**RE: Sonata Unit 4 Trails Apartments  
Tracts 1, 2, and 3, The Trails Unit 4  
Second DRB Submittal**

RESPEC, agent for Sonata Trails, LLC, owner of the above referenced property, is requesting approval from the Development Review Board (DRB) on this Site Development Plan submitted for your consideration. This is the second submittal to the DRB for this project. The first hearing was held on June 3, 2020. Below is a response to comments received at the first DRB meeting.

SHEET TITLE:  
**CONCEPTUAL SITE UTILITY PLAN**

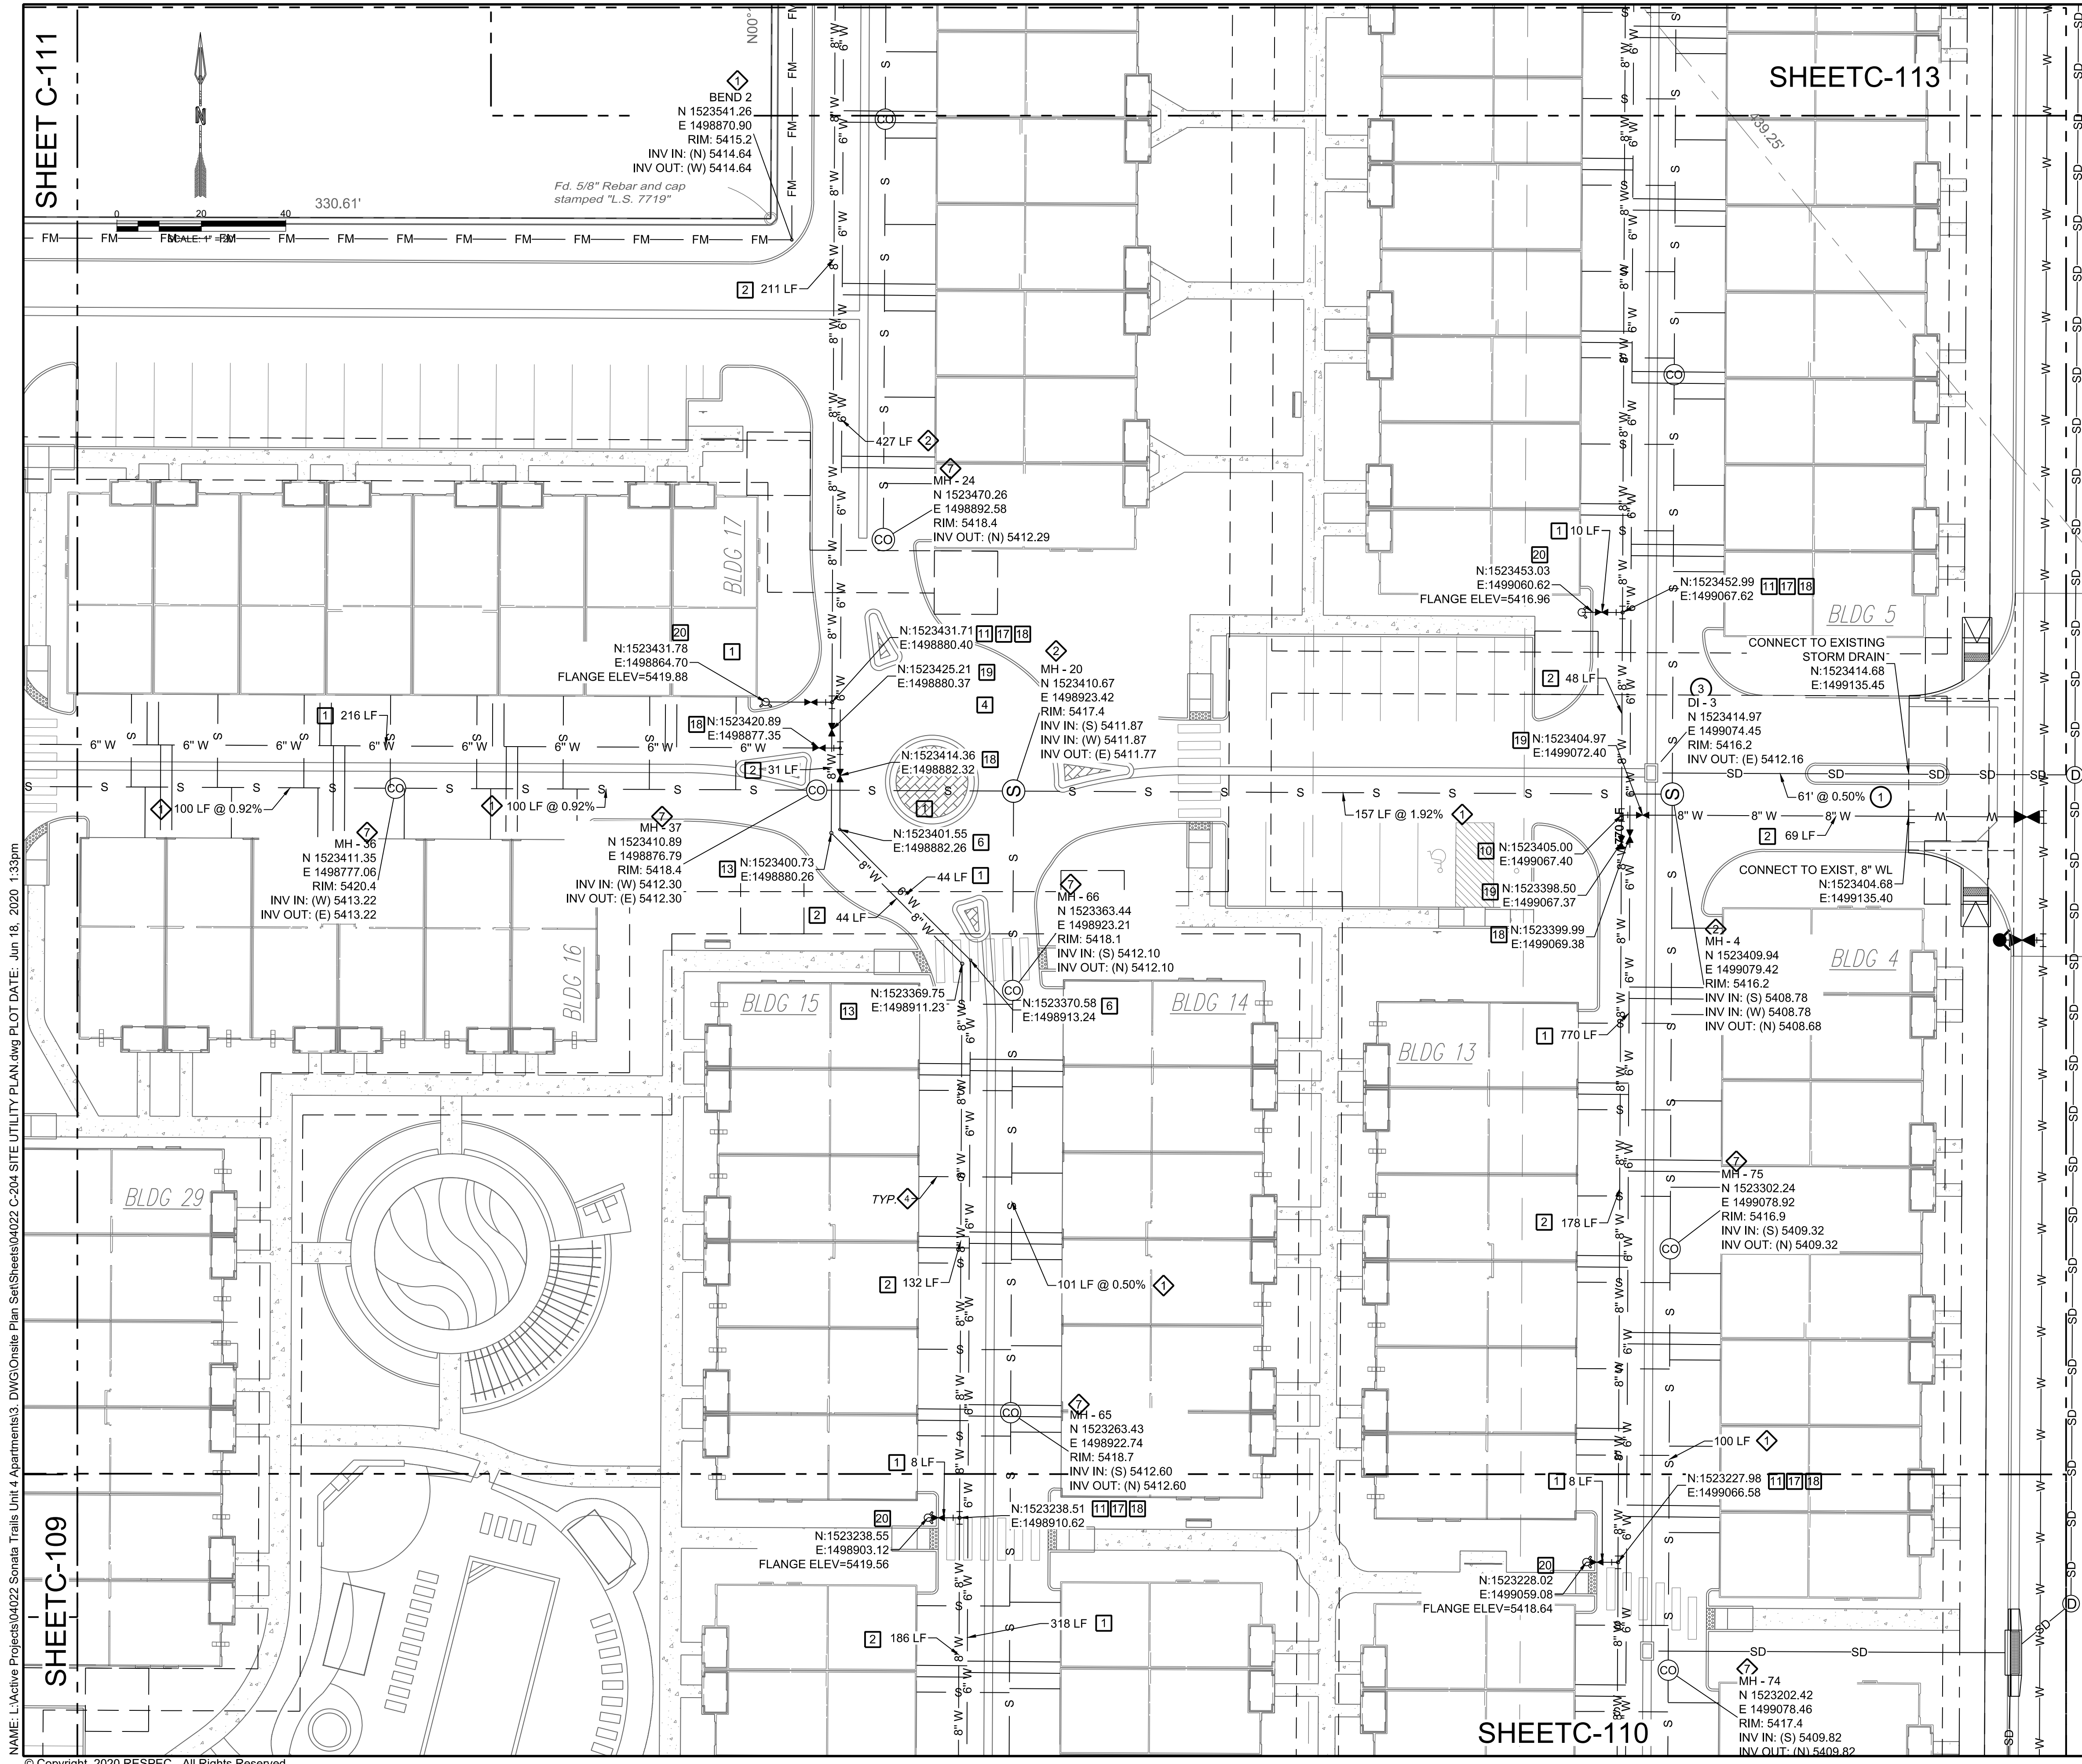
- i. Considering the potential interim condition with the private lift station, the Utility Plan should show the phases.
      1. The interim use of a private lift station and the trigger to eliminate the private lift station and discharge to public sanitary sewer that flows to the proposed interceptor along Paseo Del Norte/Avenida De Jaimito

when it is available may need to be detailed in the development agreement.

- / Detail has been added to demonstrate the phases for the private sanitary sewer. See revised utility sheets, specifically C-113.
  - d. Please confirm if the proposed manhole south of existing manhole C10302 can be eliminated by extending east directly from the existing manhole along Treeline Ave.
